KITTITAS COUNTY

MEMORANDUM

TO: All Staff
FROM: Public Works Plan Review Team
DATE: January 2nd, 2024
SUBJECT: SI-23-00003 Salmon La Sac Storage

#1 Pole Sign
Option #1

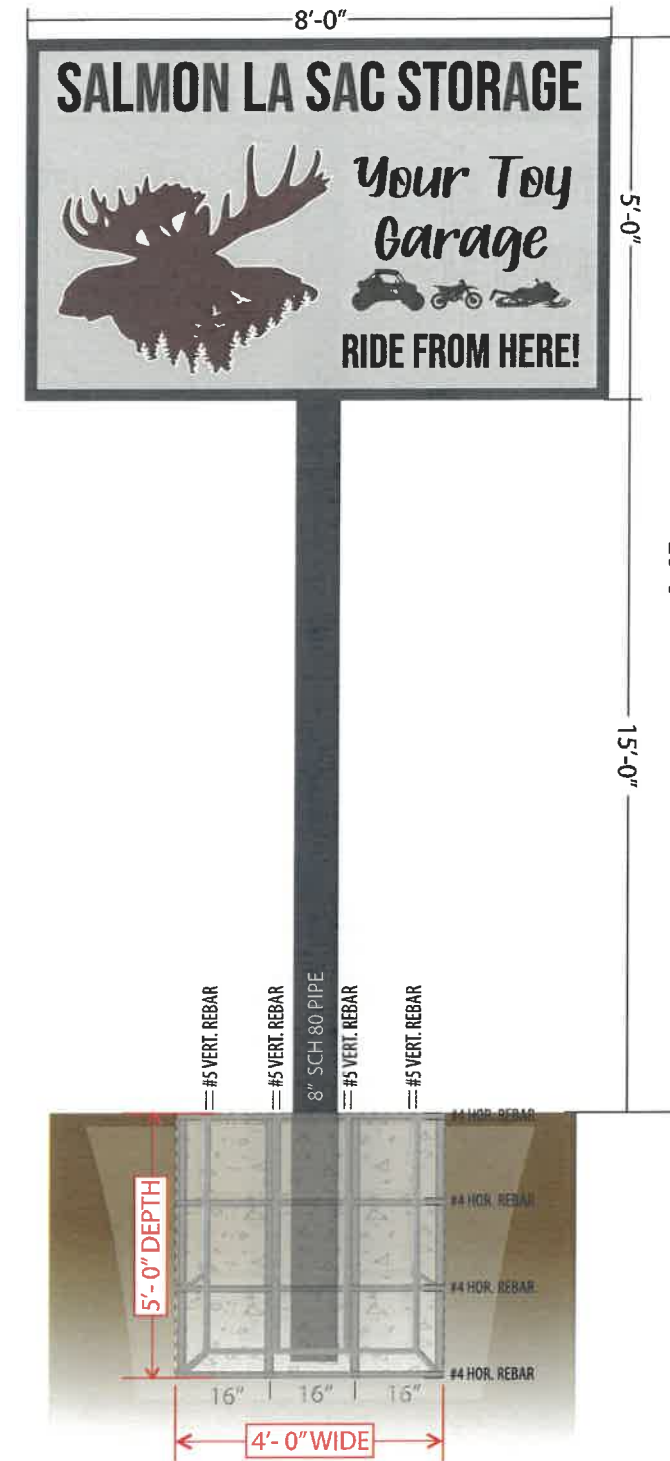
ACCESS	No comments. (JS)
ENGINEERING	Please ensure the entire sign, foundation, and excavation remain outside of the Kittitas County Right of Way. (CC)
SURVEY	No comments. (JT)
FLOOD & WATER MITIGATION/ METERING	No comments. (SC)
